DEVELOPMENT REVIEW BOARD

January 15, 2020

4. Project # PR-2019-002184  
(1001993)  
SI-2019-00379 – SITE PLAN

**REQUEST:** SITE PLAN FOR DEVELOPMENT ON A SITE UNDER 5 ACRES WITHIN 330 FEET OF MAJOR PUBLIC OPEN SPACE

SHEET TITLE: CONCEPTUAL DRAINAGE PLAN

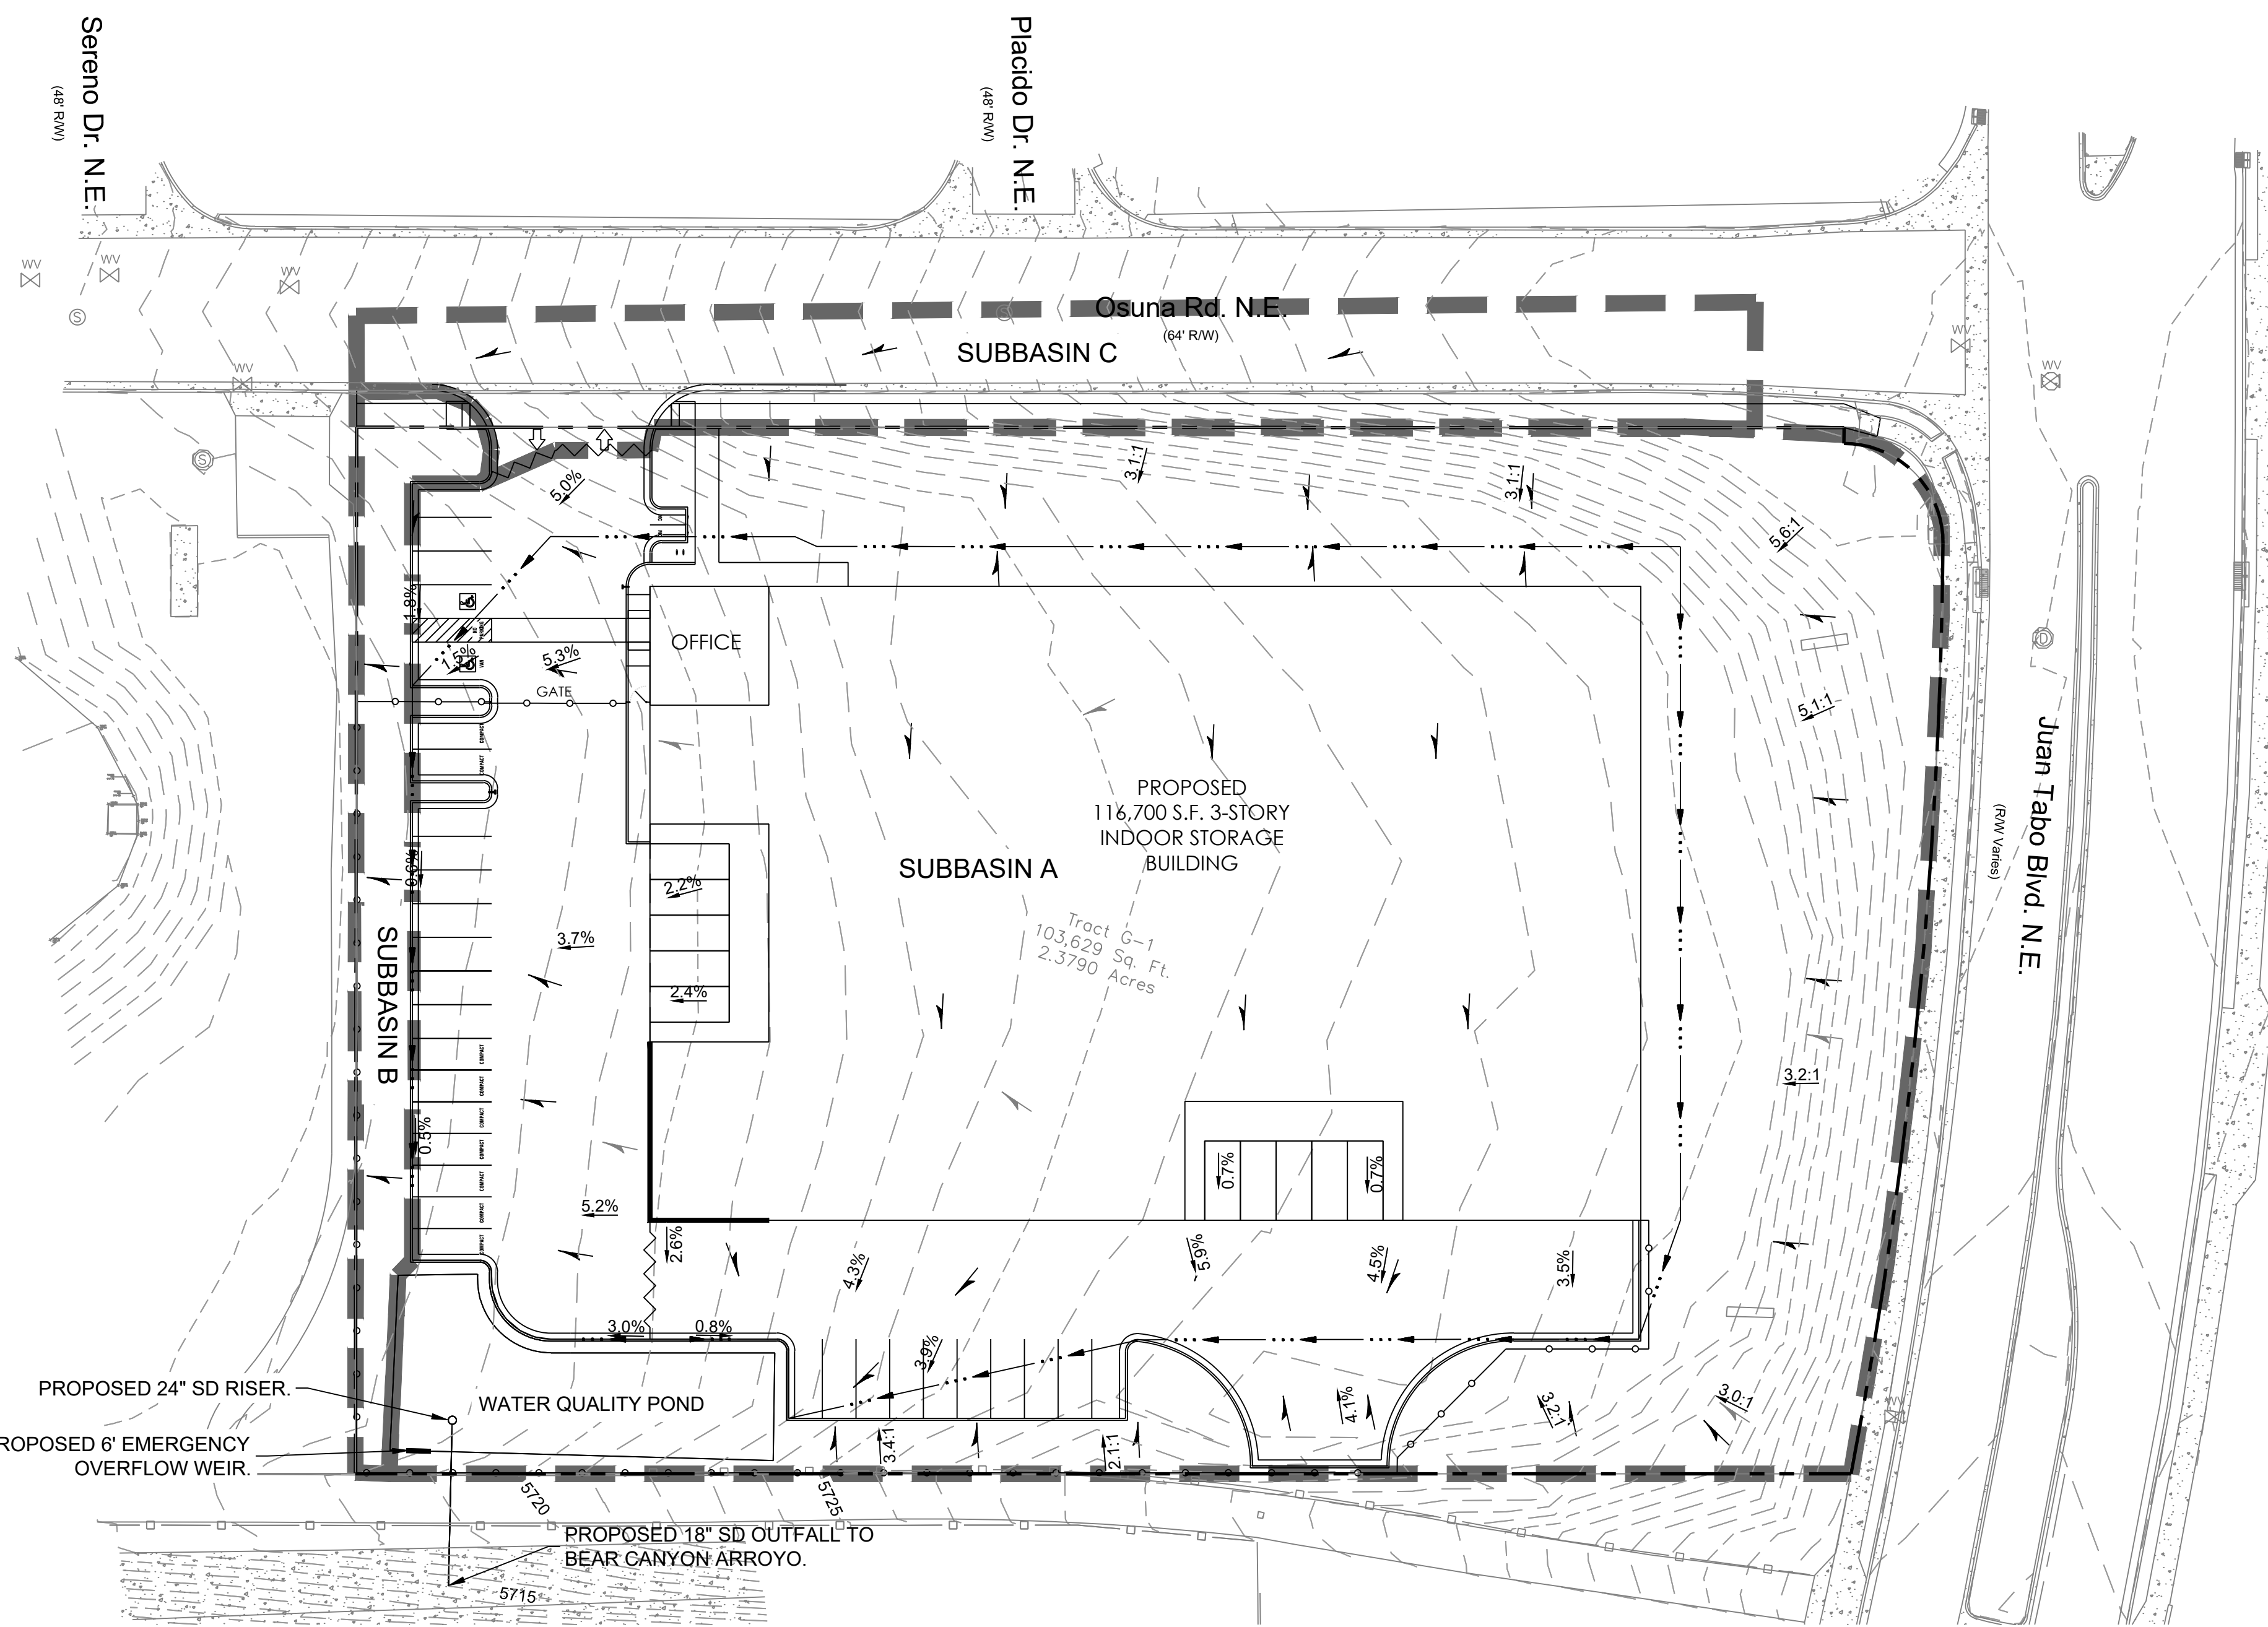
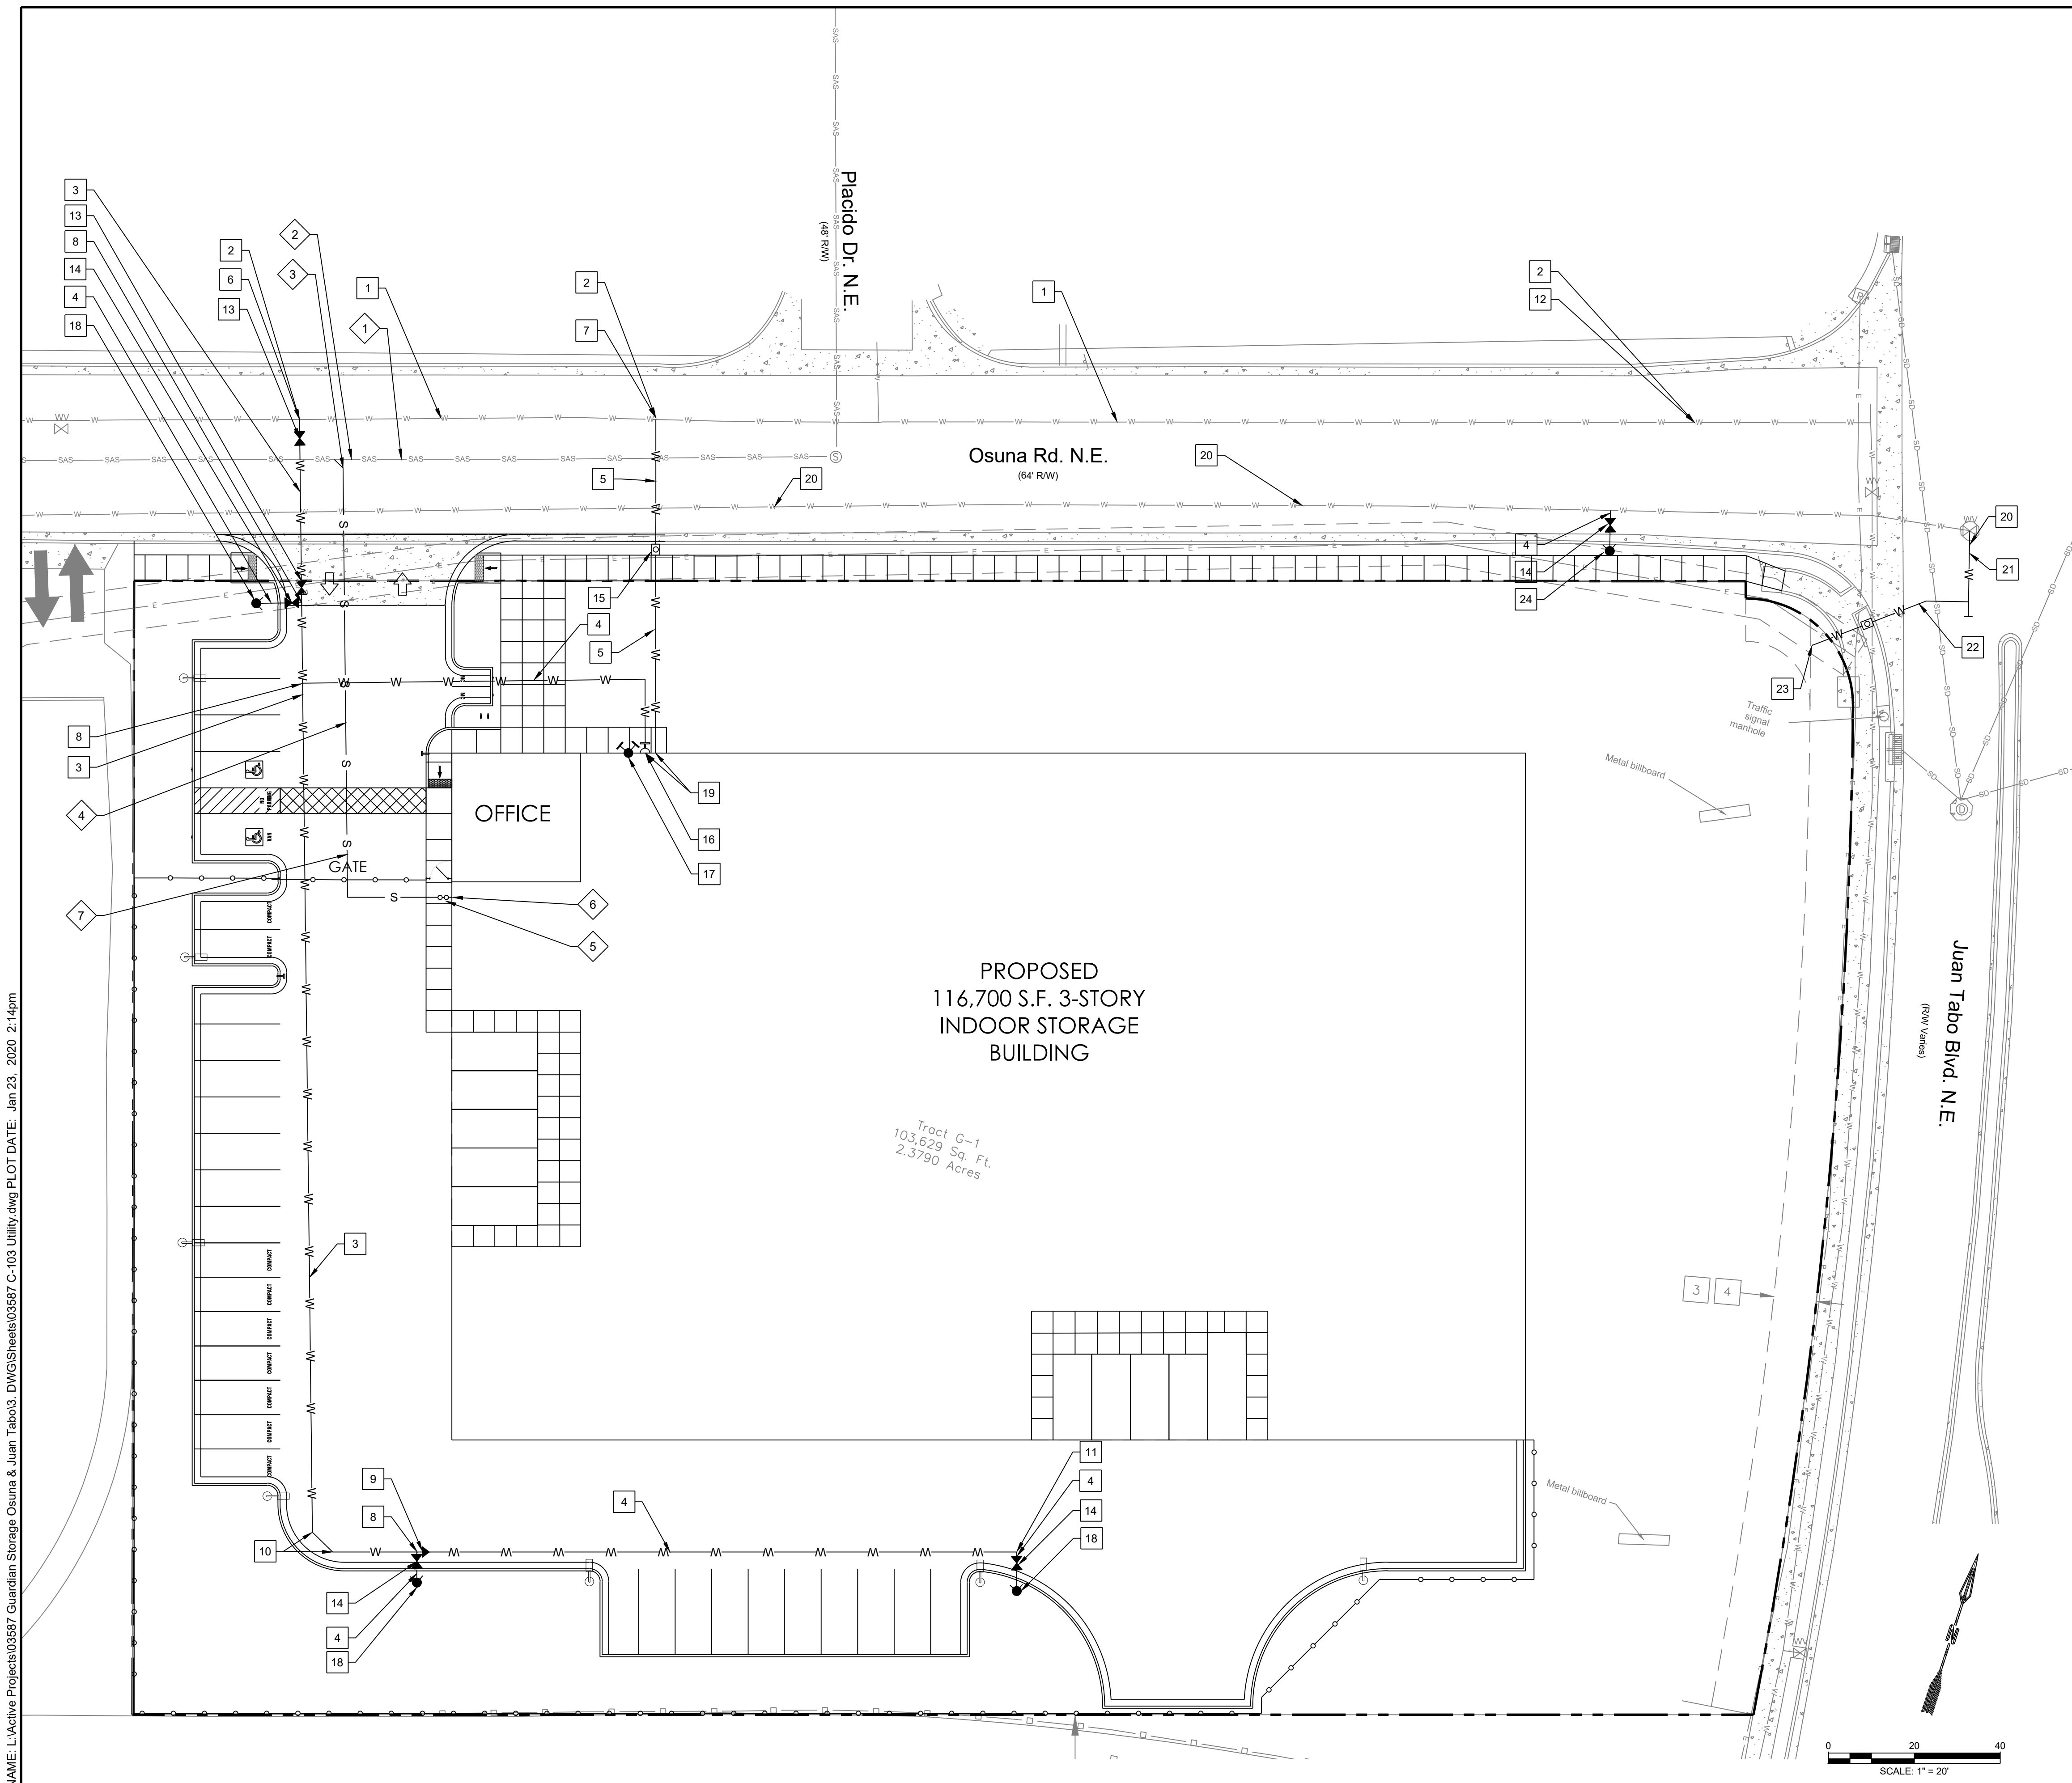
- The applicant proposes 60-75 feet of set back from Juan Tabo giving plenty of buffer between the proposed development and the Major Public Open Space. Plus, Juan Tabo is another buffer between the two.
- It is proposed to be 35 feet tall or three stories which likely won't have an impact on views when on top of the dam but I would recommend seeing some sort of photo renditions (elevation diagrams) of what it would possibly look like. The agent, Consensus Planning, may be able to render such elevation diagrams. A two story building may be a better option for viewsheds.
- Since it is a storage facility, I don't see traffic being a problem. Plus, the applicant has stated ingress/egress will be off Osuna Rd and not Juan Tabo which will lessen any issues with people who park at the dam for use of the MPOS.
- Drainage shall stay off the Multi-use Trail and the

owner/developer shall be responsible for any erosion onto the M-U Trail from the property.

- The park may be affected by drainage from the site unless addressed; similar to the comment regarding the M-U Trail.
- The storage units are all indoors so noise shouldn't be an issue with this development.
- The developer/agent shall comply with all IDO regulations pertaining to sensitive lands and specific restrictions on colors, structure design, sheltering of roof utilities should be taken into account, and landscaping should be suitable for the surrounding sensitive lands.
